Applicant: Wroxton College

Proposal: Refurbishment and repair of North Arms with Change of Use and conversion of stables into private dining facility and ancillary facilities and underground LPG tank

1. APPLICATION SITE AND SUMMARY OF SIGNIFICANCE

Drawing No
 2016-34/05E

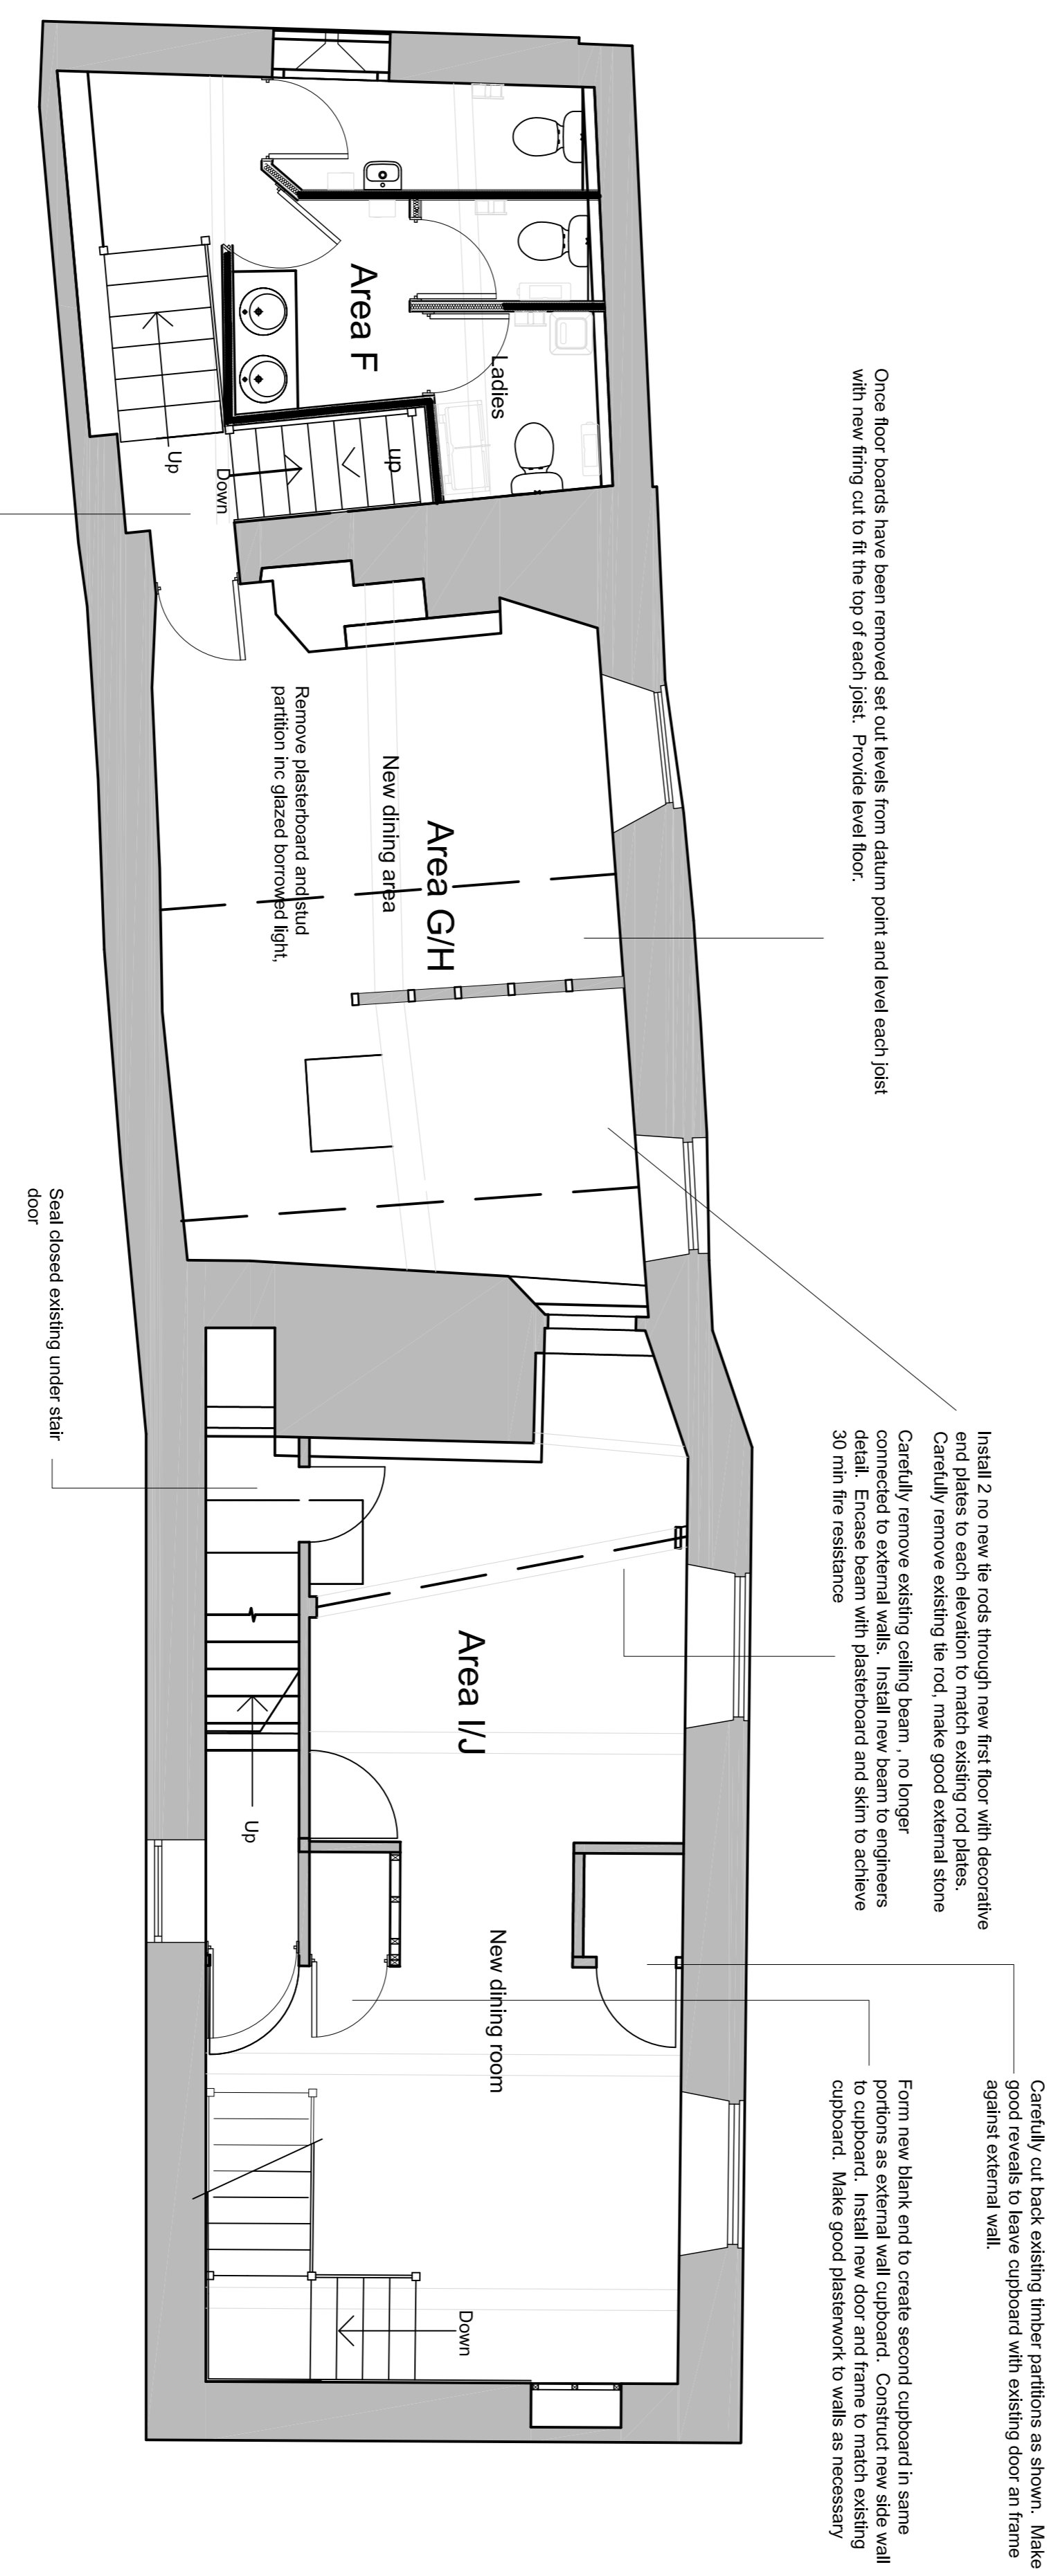
- 8.6. The main concerns relating to the internal alterations included the loss of the cross passage at first floor level (between areas I/J on the floor plans) and the loss of the historic fabric on the wall between areas G/H on the first floor of the building. These has now been resolved with the layout being amended so that the position of the cross passage can now be understood as part of the evolution of the building with the use of cupboards, potential down stand and floor detailing. The historic wall between areas G/H (one of the only remaining historic internal wall at first floor level) is also now shown to be retained in situ and whilst the loss of the door opening serving this room is not ideal it is considered to be justified to create a usable commercial layout and the fact it has been affected by earlier modern studwork. The loss of the other internal walls are largely modern walls and are not of historic significance.

- 8.10. One of the beams at first floor level in the main building needs to be replaced as it no longer connects to the external walls of the building and this is required for the long term future of the building. Full details of this will need to be conditioned.

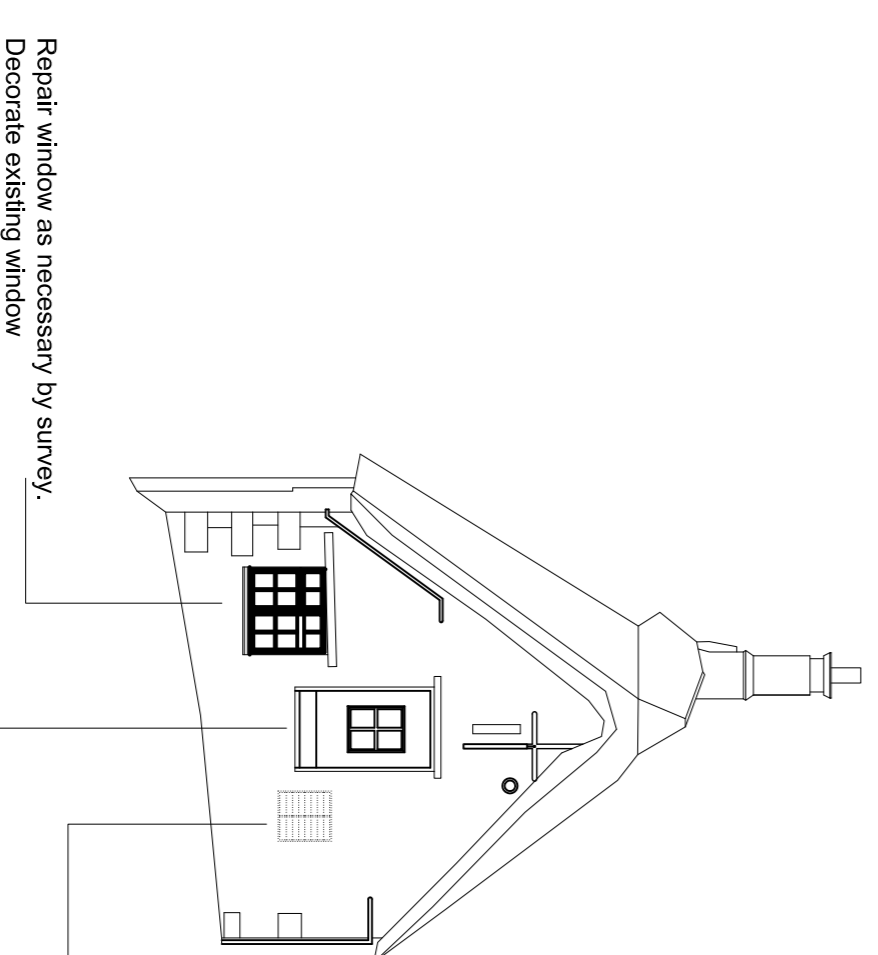
- 8.12. The removal of the existing kitchen vent in the eastern end of the building would be beneficial in heritage terms. However, the proposal does include the provision of new timber louvred features on the front and rear elevations of the single storey element of the building (western end of the building).

- 8.13. When the application was originally submitted it included the kitchen extracts in these louvres however during the course of the application, the applicant has revised the plans so that the extract from the kitchen now goes up the redundant chimney breast of the 2.5 storey building (due to noise and odour concerns). However, the applicant has retained the vents on the roof of the building to provide air intakes to the kitchen. They state this would allow the kitchen to be operate without the windows being open and would reduce noise and disturbance to neighbouring properties in this regard.

- 8.14. They have also amended the design following comments from the Conservation Officer. Whilst these details are not ideal, they are now relatively modest and the Conversation Officer is now satisfied with them subject to detail. It is noted that these elements are proposed on a more modern element of the building and would not adversely impact on the historic fabric of the building and would also allow the removal of the existing extraction system on the other end of the building. Whilst they would be clearly visible, they are not considered to dominate the building and would be seen in the context of the wider building. On the basis of the above, and noting that the proposed development is proposing to bring a new viable use to the building, on balance this is considered to be acceptable.
